To: South Holland District Council

Application Ref: H18-0879-25

Proposal: **Erection of 8 dwellings**

Location: **Land adjacent 39 Custom House Street, Sutton Bridge, Spalding, Lincolnshire, PE12 9UJ**

Drawing
 SITE PLAN - EXISTING & PROPOSED
 LOCATION PLAN

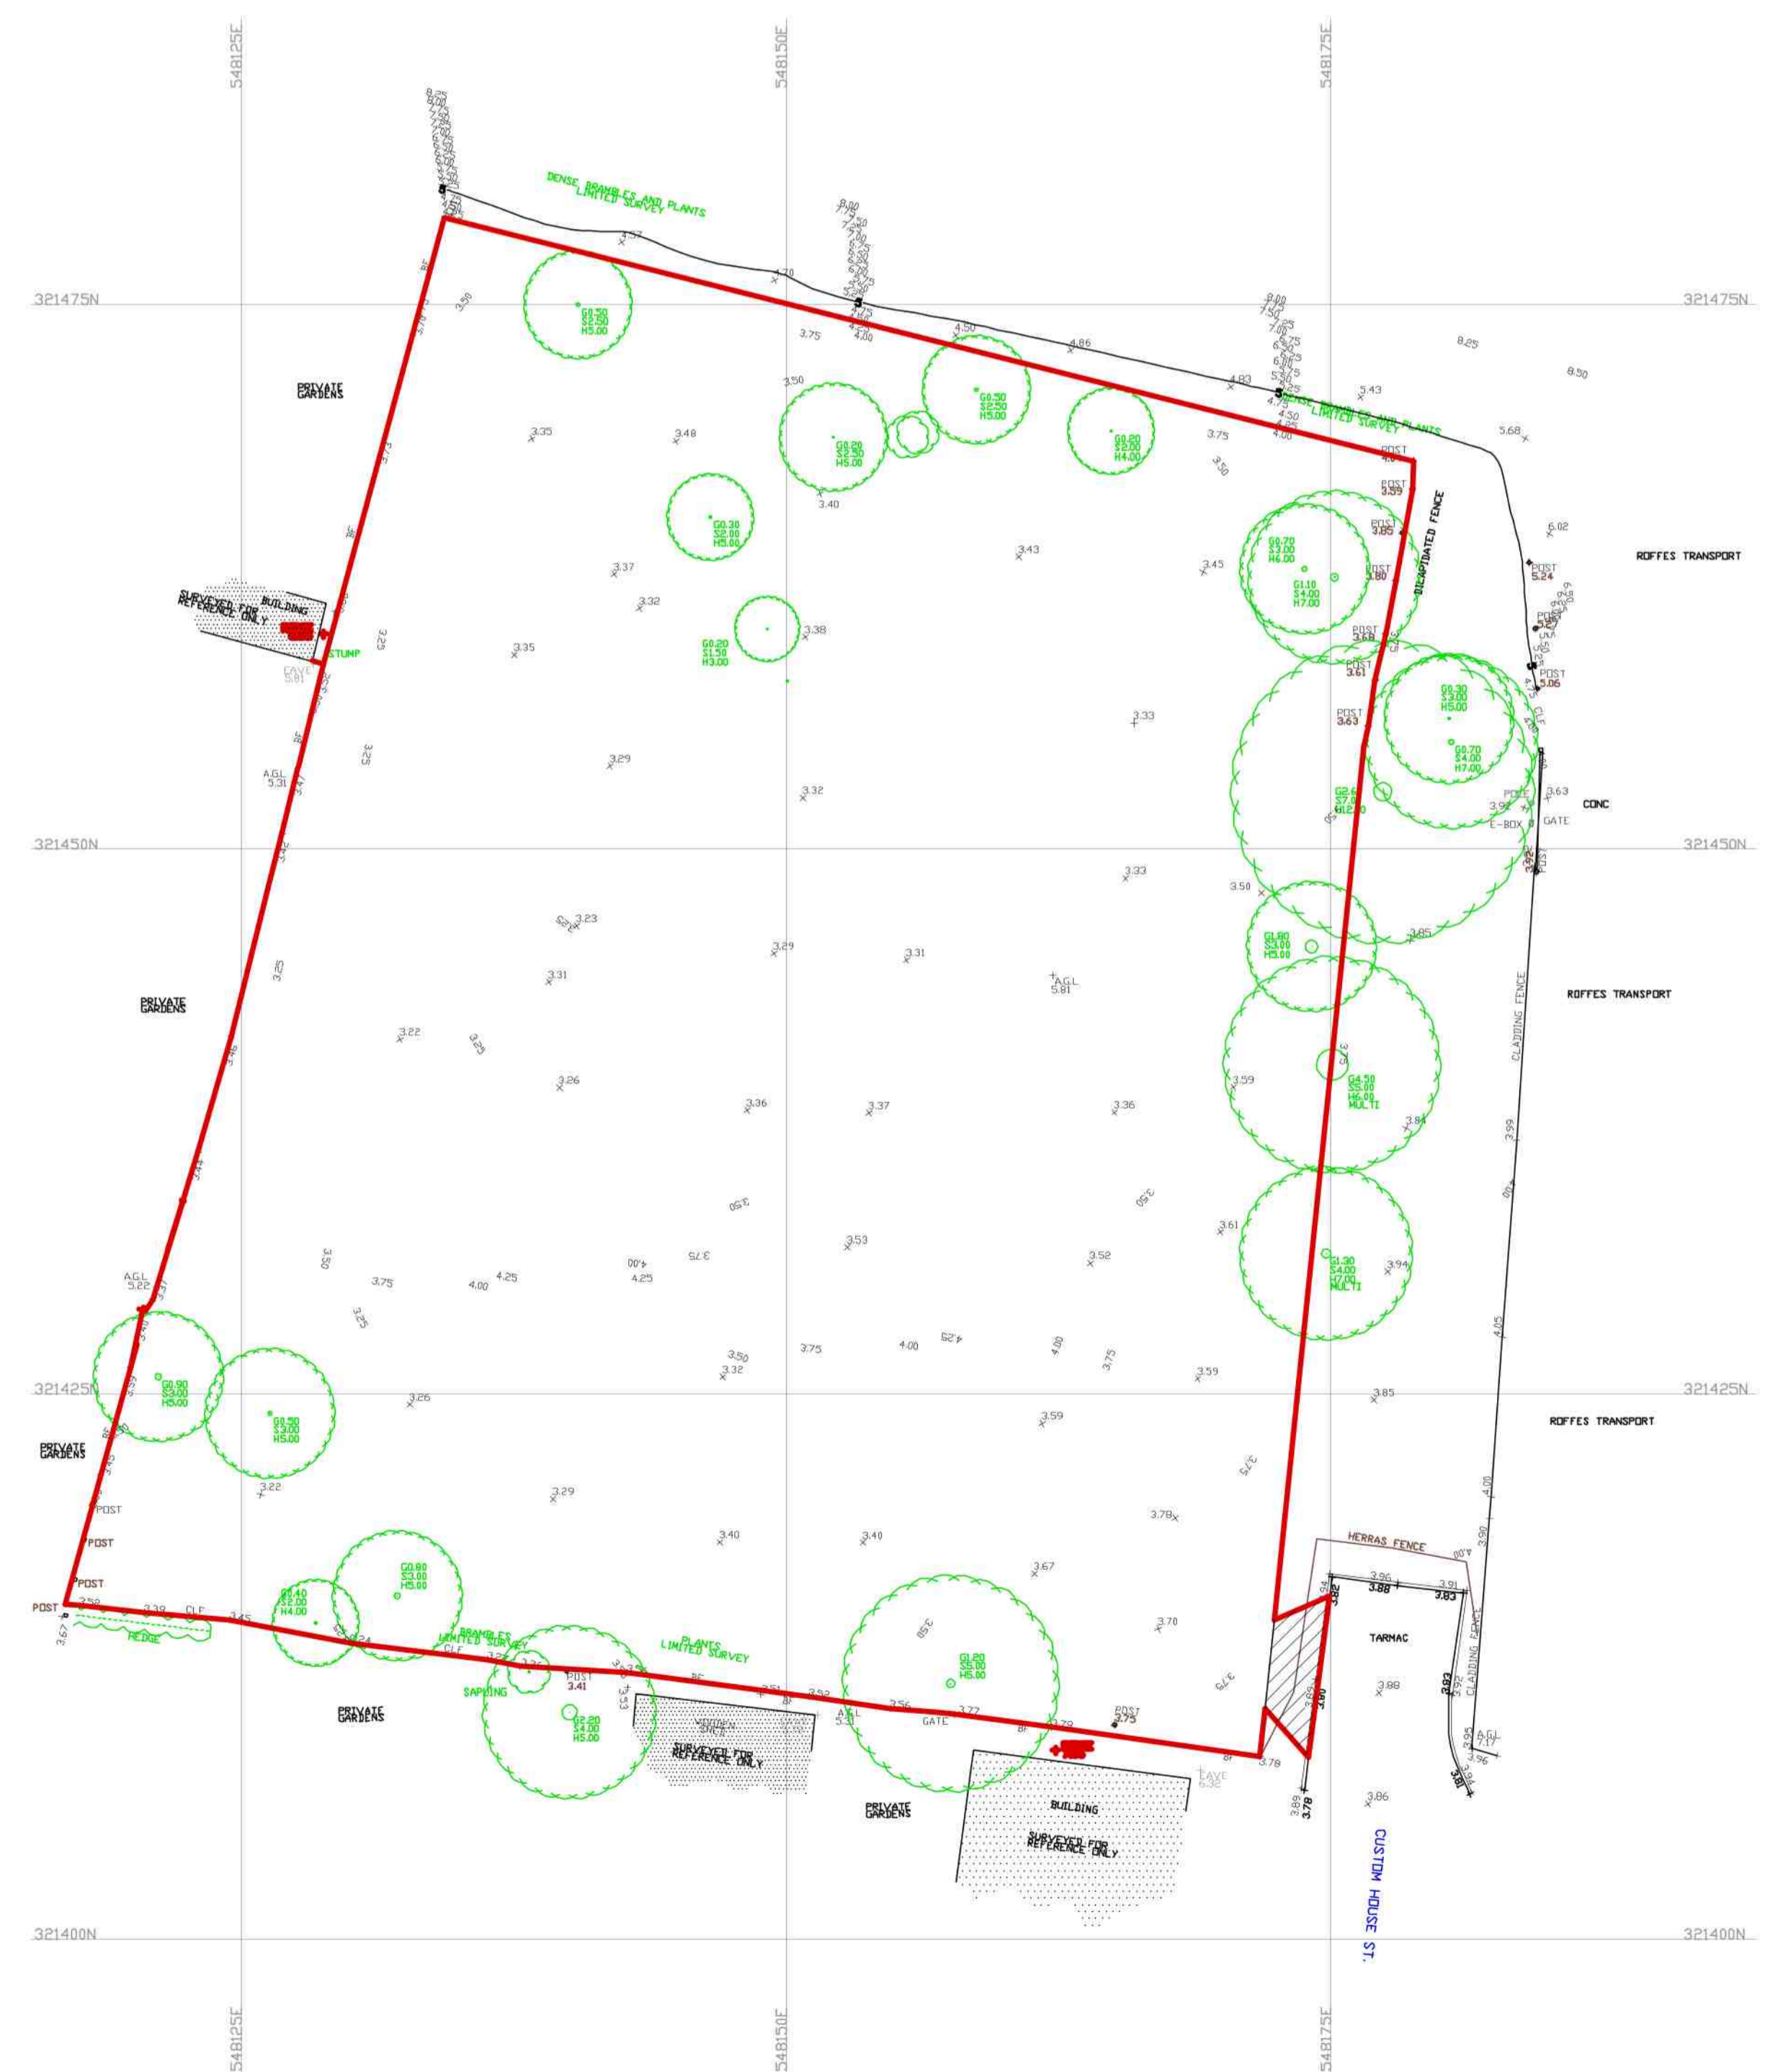
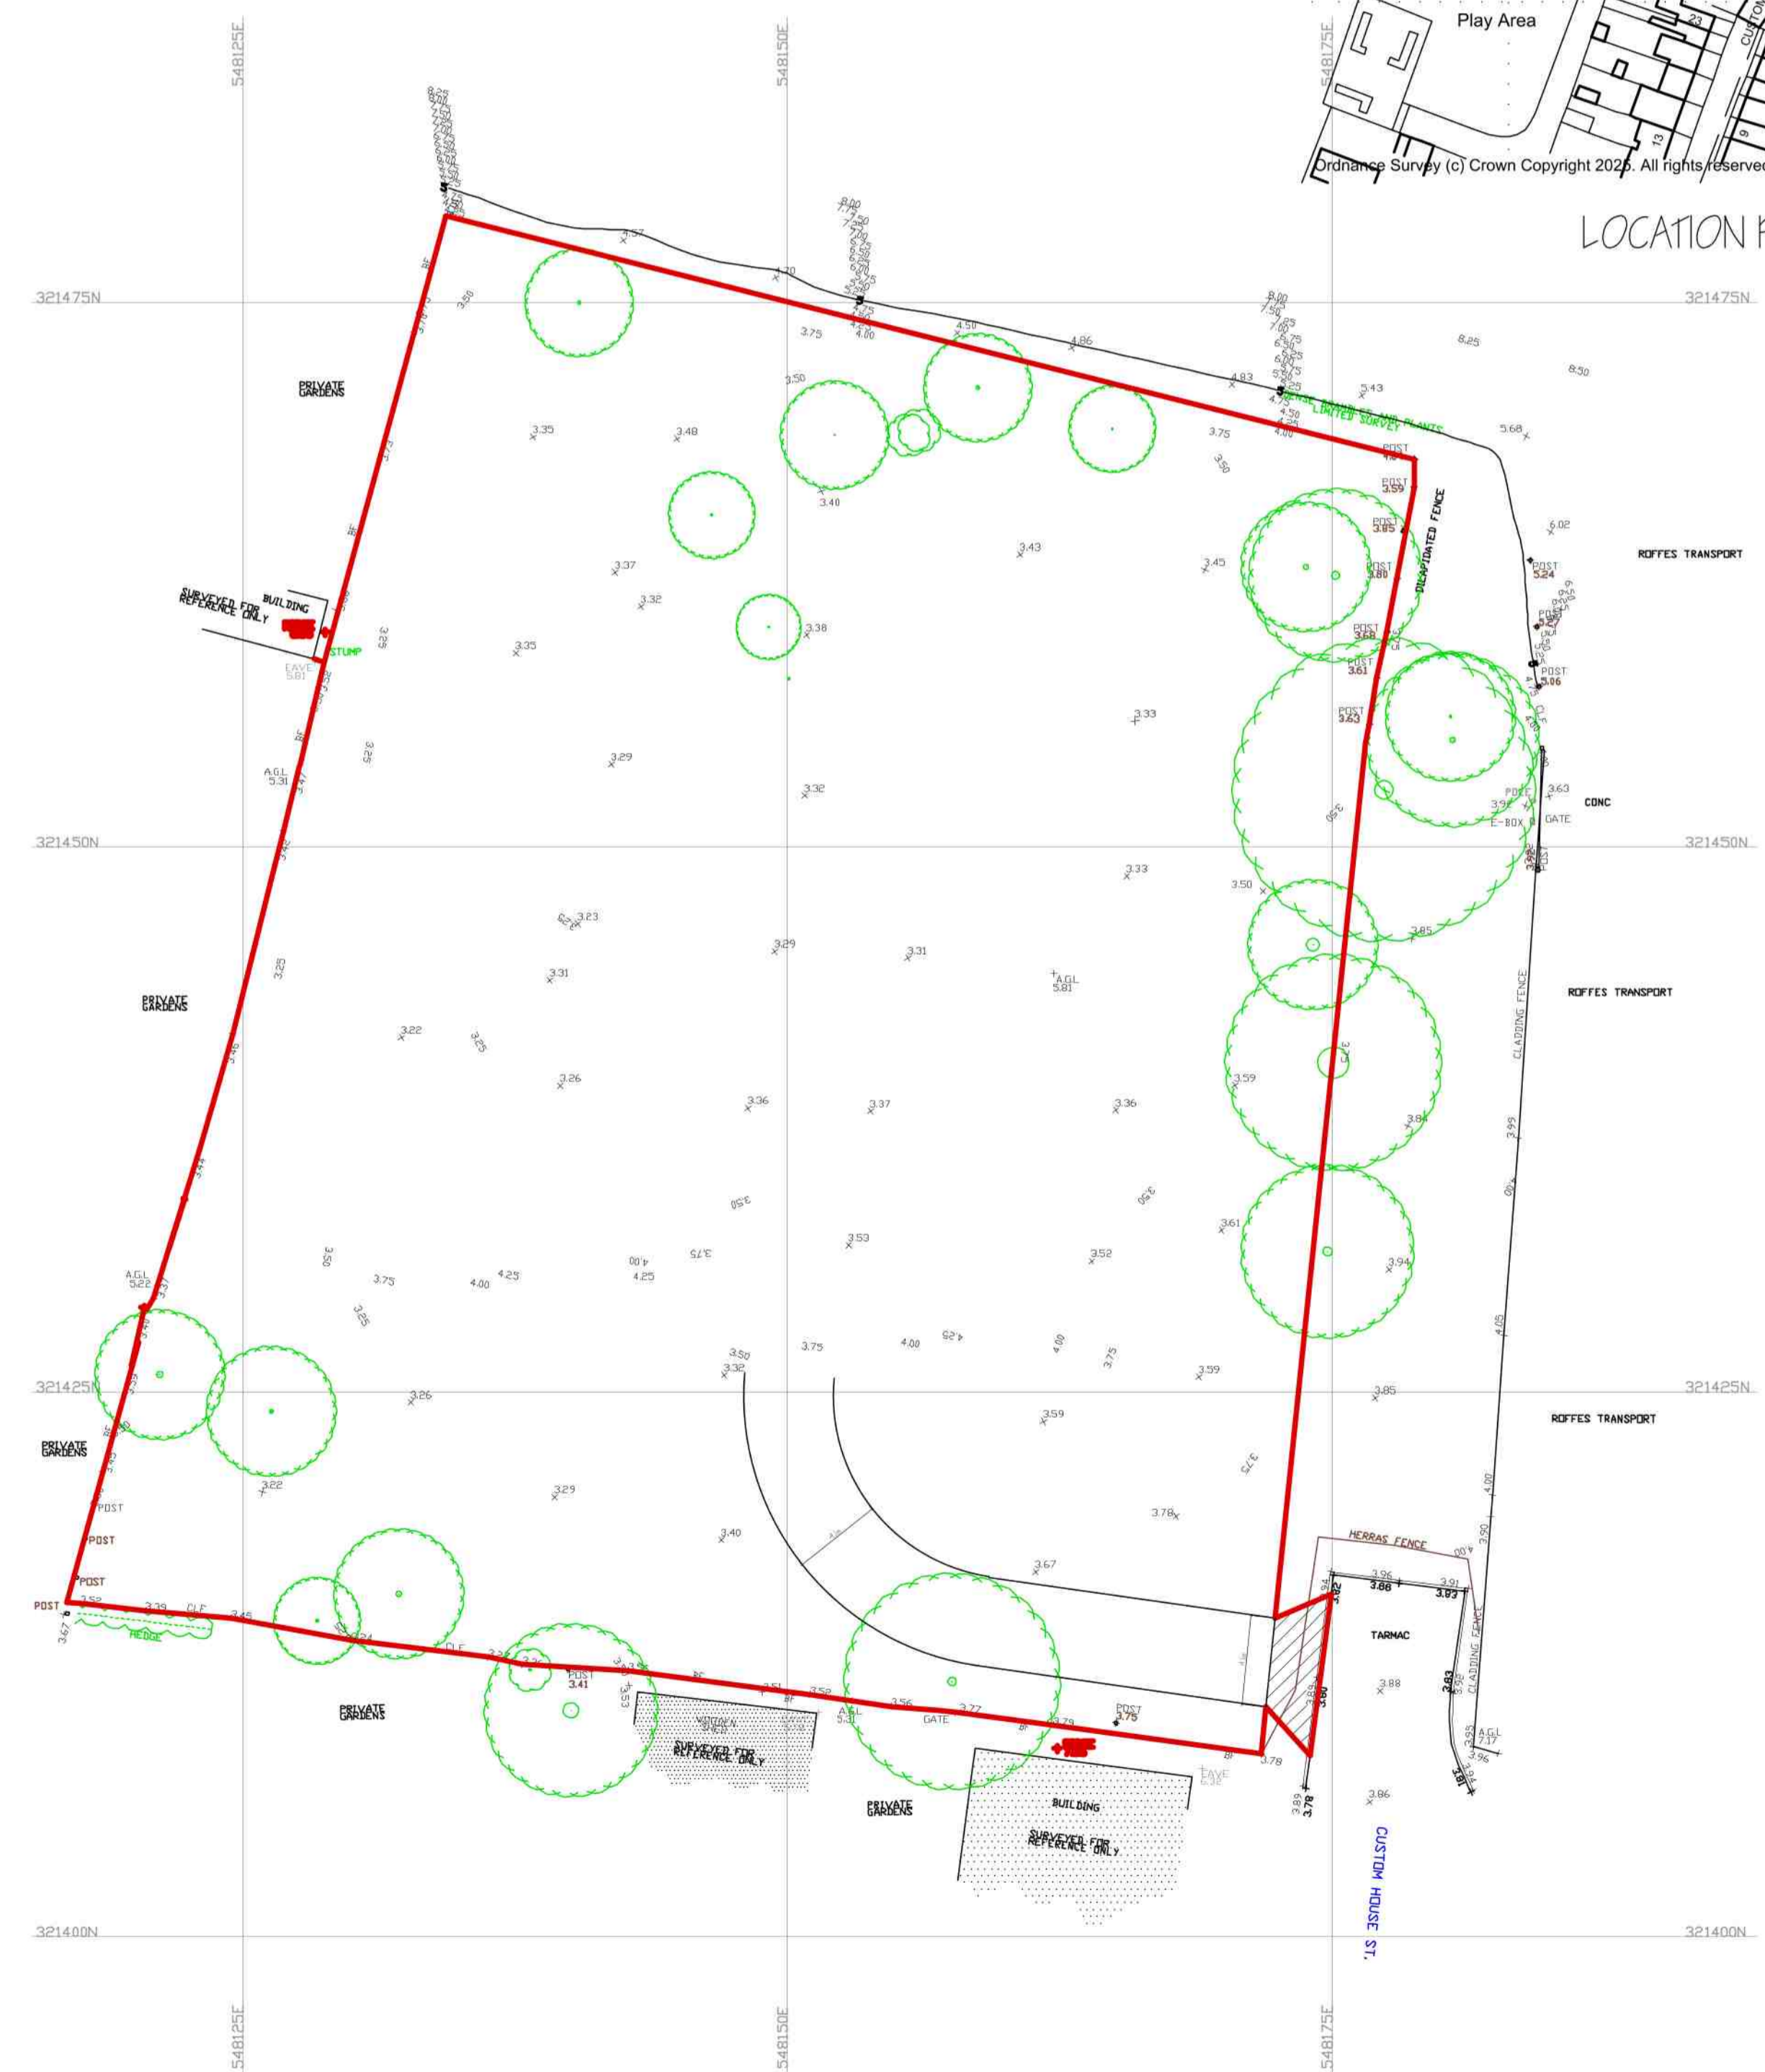
There is a possible ransom strip – no blue outline has been detailed on the location plan. Who owns the strip of land between the highway and the hatched area on the site plan? I have sent a plan to Planner.
